From: Simon Davis
Sent: 04 September 2013 15:02
To: Planning.Responses
Subject: FW: BR/201/13/DOC - 3 Marine Drive West, Bognor Regis

Looking over the details in the Energy Statement and also the details of the system spec I am afraid that I still have some issues at the moment that make it hard for me to be able to agree to Condition 6 being discharged.

The planning condition in question (06) states:

Bivalent and Integrated Heating Systems

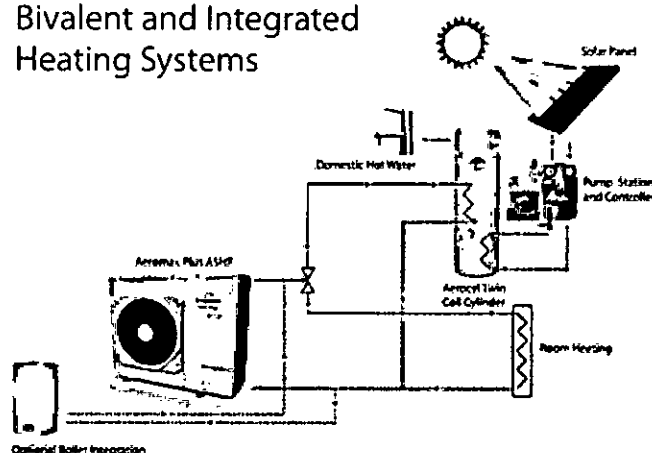
Overall I have issues in terms of the figures that they have within the Energy Statement in that I am unable to come out with the same figures. Also when looking at both the energy statement and the Kingspan leaflet about the intended systems I get confused with the information, or lack of it, that has been provided. In the Energy Statement they discuss solar hot water systems but state in the recommendation that it would be impractical in terms of the pipework to the lower levels and in terms of only providing 6% of the site energy requirement. In terms of Solar PV they leave the recommendation completely open ended. Logically from what they are saying it would seem that the amount of space means that it would not be possible, however they do not actually state that this is the case. As mentioned at the beginning in comparing what they then say about the air source heat pumps and what is in the information leaflet and the figures provided I am unable to confirm their recommendation. Furthermore when comparing the two, it would seem that the use of the gas boiler means they must be going down the route of a

Bivalent and Integrated System. Again however they have not explained the situation in their Energy Statement and on the figures within it I am not able to confirm their recommendation as I am unable to get the same figures.

I would suggest that further clarification needs to be added into the Energy Statement and that the figures need to be sorted. As Jo has suggested, having the coefficients and/or ratios expected would be the most helpful thing in this respect.

4. ON-SITE RENEWABLE ENERGY SOURCES

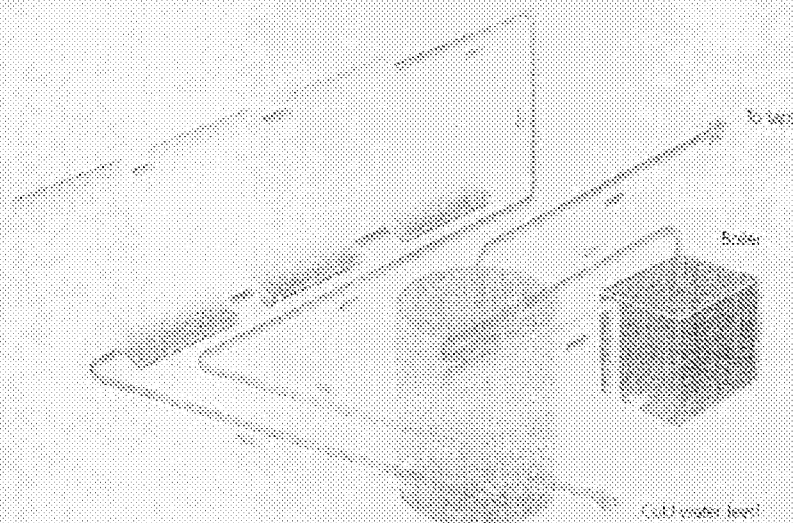
On a more personal note I feel that the option of solar water heating or PVs have discounted too easily. I feel that something potentially combining the two may create more guaranteed savings. Potentially this may be done through them being applied to only the number that are feasible (such as the top 2 flats specifically or 2/3 floors).
